Lower Thames Crossing

9.214 Applicant's comments on Interested Parties' submissions at Deadline 8

DATE: December 2023
DEADLINE: 9

Planning Inspectorate Scheme Ref: TR010032
Examination Document Ref: TR010032/EXAM/9.214

*Local Landscape Character Area boundaries of the Kent Downs AONB LCA, West Kent Downs, Sub-areas Cobham and Shorne*

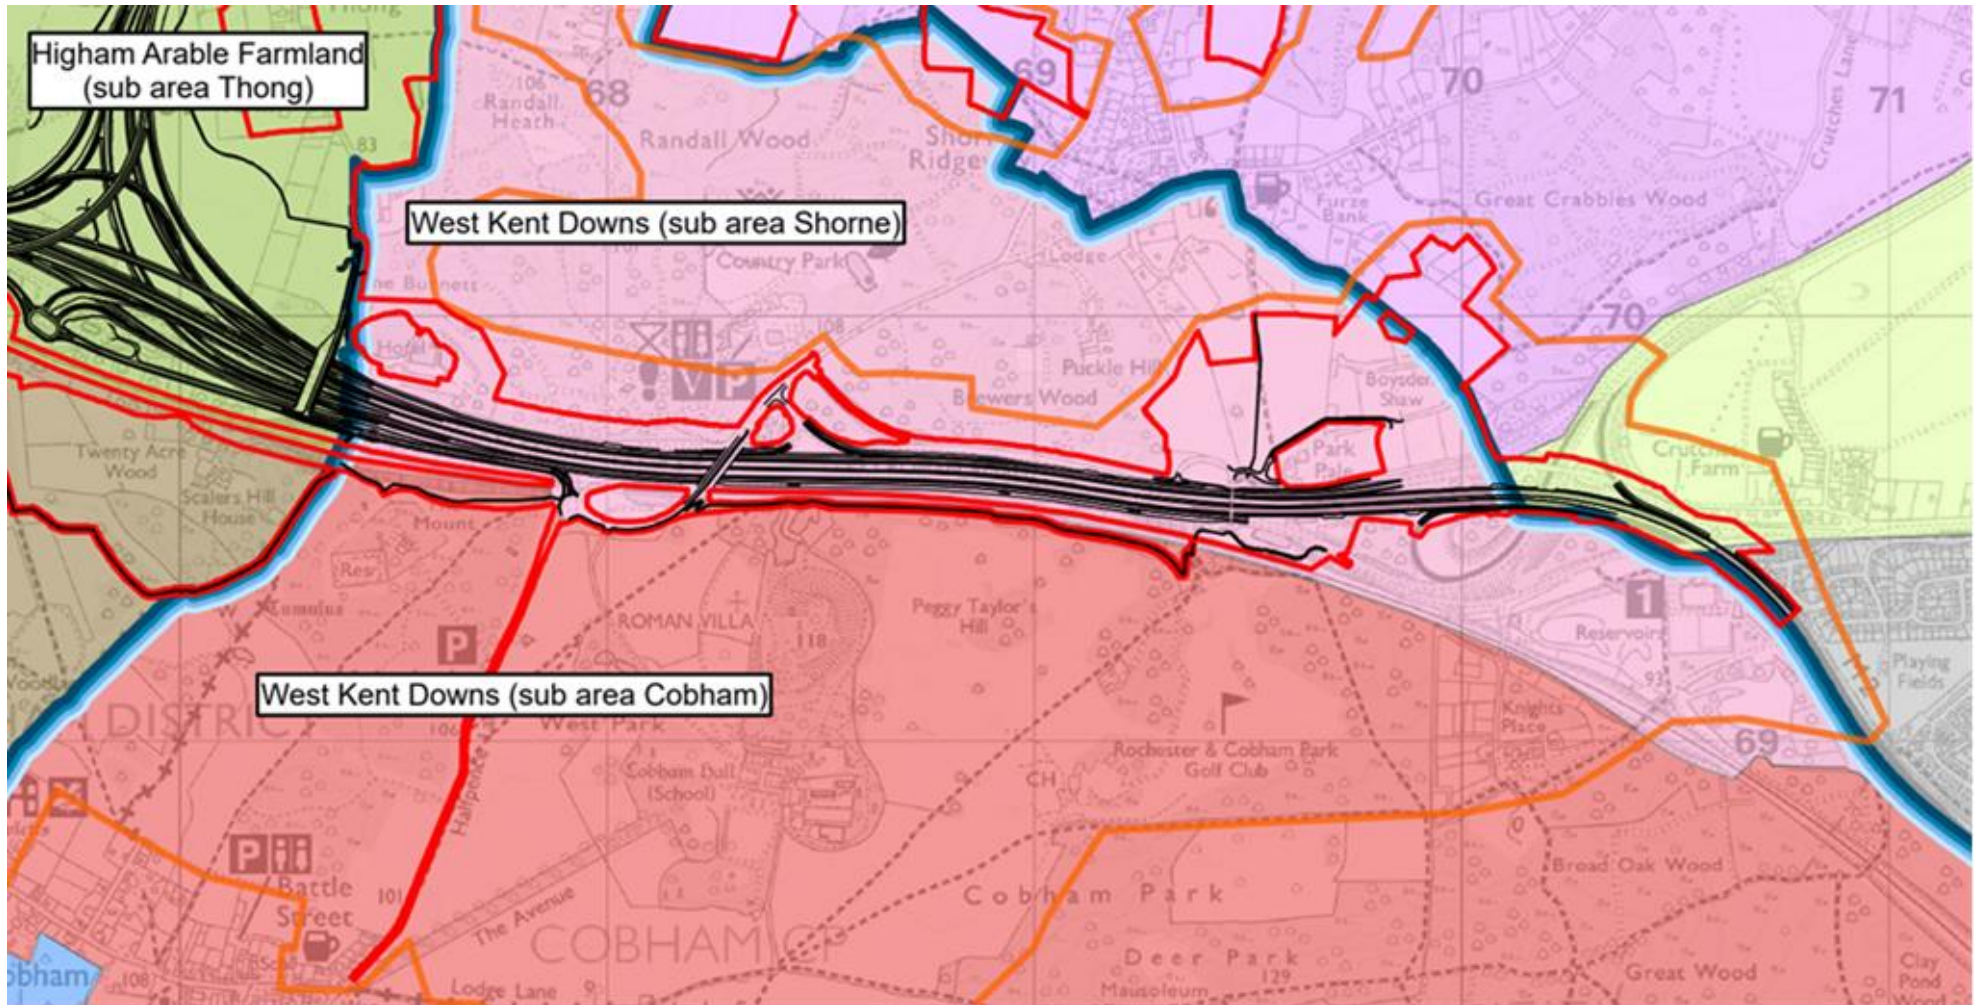
Deadline 8 Submission - Appendix 1a - Response to ISH11 Action Points 4,5 and 14	Gravesham Borough Council	<p>Link to IP's submission: [REP8-127]</p> <p>Applicant's response:</p> <p>In their Deadline 8 submission on Issue Specific Hearing 11 agenda item 3a)i [REP8-127], Gravesham Borough Council are not correct to say that <i>'it is unfortunate that visuals of the proposed A2 junction were not available for the Hearing...'</i> The Applicant notes that it has provided the following visualisations to illustrate the proposed M2/A2/A122 Lower Thames Crossing junction:</p> <ul style="list-style-type: none"> • Photomontage S-22 in ES Figure 7.19 Photomontages Winter Year 1 and Summer Year 15 (1 of 4) [Document Reference 6.2 ES Figure 7.19 1 of 4 (5)] and photomontages S-25 and S-28 in ES Figure 7.19 Photomontages Winter Year 1 and Summer Year 15 (2 of 4) [Document Reference 6.2 ES Figure 7.19 2 of 4 (3)] • Enhanced Cross Sections (Part 1 of 2) [REP2-069] and Enhanced Cross Sections (Part 2 of 2) [REP2-071] <p>In relation to Gravesham Borough Council's Deadline 8 submission on Issue Specific Hearing 11 agenda item 3a)iii [REP8-127] post hearing updates (final paragraph), the Applicant also notes that the following visualisations were provided at Deadline 7:</p> <ul style="list-style-type: none"> • Computer Generated Views from Thong Lane green bridge south [REP7-189] (published on PINS website on 22 November 2023) <p>In their Deadline 8 submission on Issue Specific Hearing 11 agenda item 3a)ii [REP8-127], Gravesham Borough Council state that <i>'The documents [landscape character assessments by Kent County Council,</i></p>

Document title	Interested Party (IP)	Link to IP's submission / Applicant's response
		<p>Gravesham Borough Council and the Kent Downs AONB] <i>show the boundary between the West Kent Downs (sub-area Cobham) Local Landscape Character Area (LLCA) and WK Downs (sub-area Shorne) LLCA runs along the southern boundary of the east bound A2 carriageway, placing the central reservation woodland in the Cobham sub-area to the south</i>'. However, the Applicant contends that it is not possible to confirm Gravesham Borough Council's interpretation of the character area boundary from the small-scale maps provided in the published landscape character assessments. Furthermore, the statement by Gravesham Borough Council in their Deadline 8 submission appears to contradict the Gravesham Landscape Character Assessment (Gravesham Borough Council, May 2009), which describes the geographical area of 'Shorne Woodlands' (the Gravesham landscape character area corresponding to the Kent Downs AONB Unit Local Landscape Character Area of the West Kent Downs sub-area Shorne) at page 27 as follows:</p> <p><i>'Shorne Woodlands is located to the south east of Gravesend. The combined corridor of the Channel Tunnel Rail Link and the A2 form the southern boundary, with the A289 forming the boundary to the east.'</i> (Applicant's emphasis)</p> <p>The Gravesham Landscape Character Assessment therefore implies that HS1 defines the southern boundary of the character area. Notwithstanding, the Applicant notes the following guidance from Natural England in An Approach to Landscape Character Assessment (Natural England, 2014) in relation to landscape character area boundaries:</p> <p><i>'...boundaries are rarely precise and generally represent zones of transition...Detailed, district and local assessments often link boundaries to specific features in the landscape, e.g. @ 1:25,000 or 1:10,000 scale, but even at this scale the boundary line may mark a zone of transition.</i></p> <p><i>Mapped boundaries may suggest that there is a sharp change from one landscape to another, generally however, on site it can be seen that a boundary line represents a zone of transition from one landscape to another - character rarely changes abruptly</i>'.</p> <p>The Applicant therefore maintains the appropriateness of the landscape character area boundary shown on ES Figure 7.2 [APP-198] for the purposes of the landscape impact assessment in ES Appendix 7.9 [Document Reference 6.3 ES Appendix 7.9 (2)] and for the reasons previously given in responses to ExQ1 and ExQ2.</p> <p>In relation to Gravesham Borough Council's Deadline 8 submission on Issue Specific Hearing 11 agenda item 3a)iii [REP8-127] post hearing update regarding the Deadline 7 update to the Design Principles [REP7-140], the Applicant confirms that it is not the intention of the amended clauses to combine planting on one side of the bridge or the other. The Applicant also confirms that the assumptions for the landscape</p>

Document title	Interested Party (IP)	Link to IP's submission / Applicant's response
		<p>and visual impact assessment in ES Chapter 7: Landscape and Visual [Document Reference 6.1 ES Chapter 7 (2)] (planting on both sides of the bridges) remain valid.</p> <p>The reason for the revised wording of the Design Principles was to allow flexibility at detailed design stage to help meet the design aspirations of key stakeholders, including Kent Downs AONB Unit, for the green bridges. However, to provide greater certainty, a further amendment to the wording of the Design Principles has been made [Document Reference 7.5 (7)].</p>
Deadline 8 Submission - Appendix 1b - Response to ISH11 Action Point 8	Gravesham Borough Council	<p>Link to IP's submission: [REP8-128]</p> <p>Applicant's response: In their Deadline 8 response to Issue Specific Hearing 11 Action Point 8 [REP8-128], Gravesham Borough Council are not correct to say that <i>'the DMRB LA107 guidance referred to by the Applicant does not state that the separate assessments of landscape effects and visual assessment effects should be combined into a single conclusion.'</i> The Applicant notes that Design Manual for Roads and Bridges (DMRB) LA 107 (Highways England, 2020b) clearly states in paragraph 2.7 that: <i>'The effect of a project on the landscape and visual amenity shall be assessed independently and the outcome combined to a single conclusion of the likely significant effect on landscape and visual amenity'.</i> Paragraph 7.9.22 of ES Chapter 7: Landscape and Visual [Document Reference 6.1 ES Chapter 7 (2)] explains the basis of the Applicant's single conclusion in the context of the range of landscape and visual effects likely to arise from the Project. For the effects on specific landscape and visual receptors, reference should be made to the detailed assessments in ES Appendix 7.9: Schedule of Landscape Effects [Document Reference 6.3 ES Appendix 7.9 (2)] and ES Appendix 7.10: Schedule of Visual Effects [Document Reference 6.3 ES Appendix 7.10 (2)].</p>
